From: [Holly Erdman](#)
To: ["Marc Kirkpatrick"](#)
Cc: [Kelly Bacon \(CD\)](#)
Subject: RE: Notice of Application SP-20-00004 Hein
Date: Thursday, August 13, 2020 4:46:57 PM
Attachments: [image001.png](#)
[image002.png](#)

Subject: Notice of Application SP-20-00004 Hein

Drawing file: SP-20-00004 Hein / 19096-TOPO-BNDRY (8-7-2020).pdf

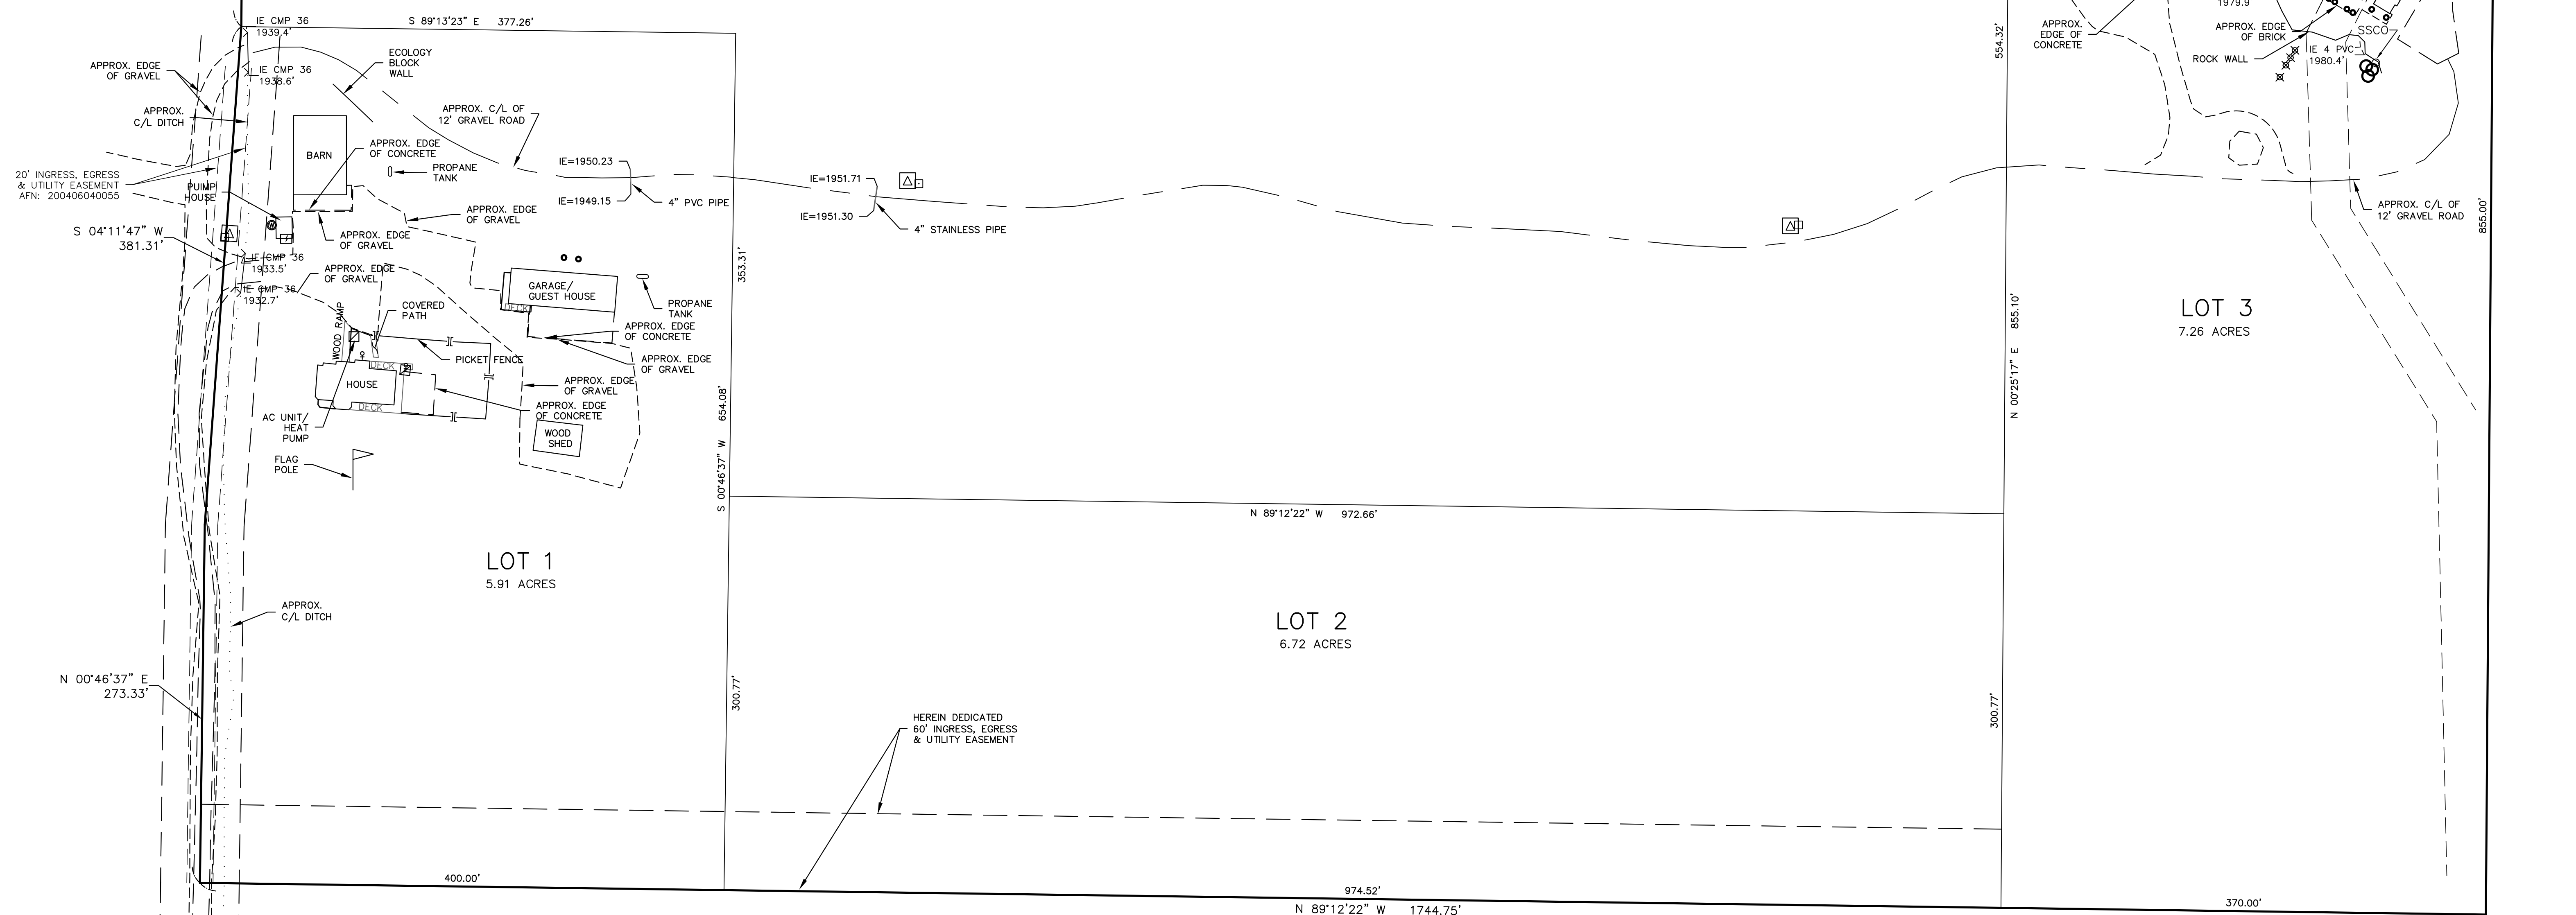
The north property line for lot 3 needs to be relocated to be at least 50 feet from the existing well.

Thank you, how far from the proposed property line is the well? I see the scale but am unsure of it's accuracy. If this distance could be obtained that would be helpful.

Can you please assist with the location of the proposed well on lot 3 of the proposed Hein Short Plat, please.

For the proposed lot 3, I am having difficulty determining the location of the well. Can you help with this? This information is needed.

Currently it is 33-ft, but we have flexibility to adjust this line or provide a protective buffer easement around it.

See attached for the well location on Lot 3 from the applicant.
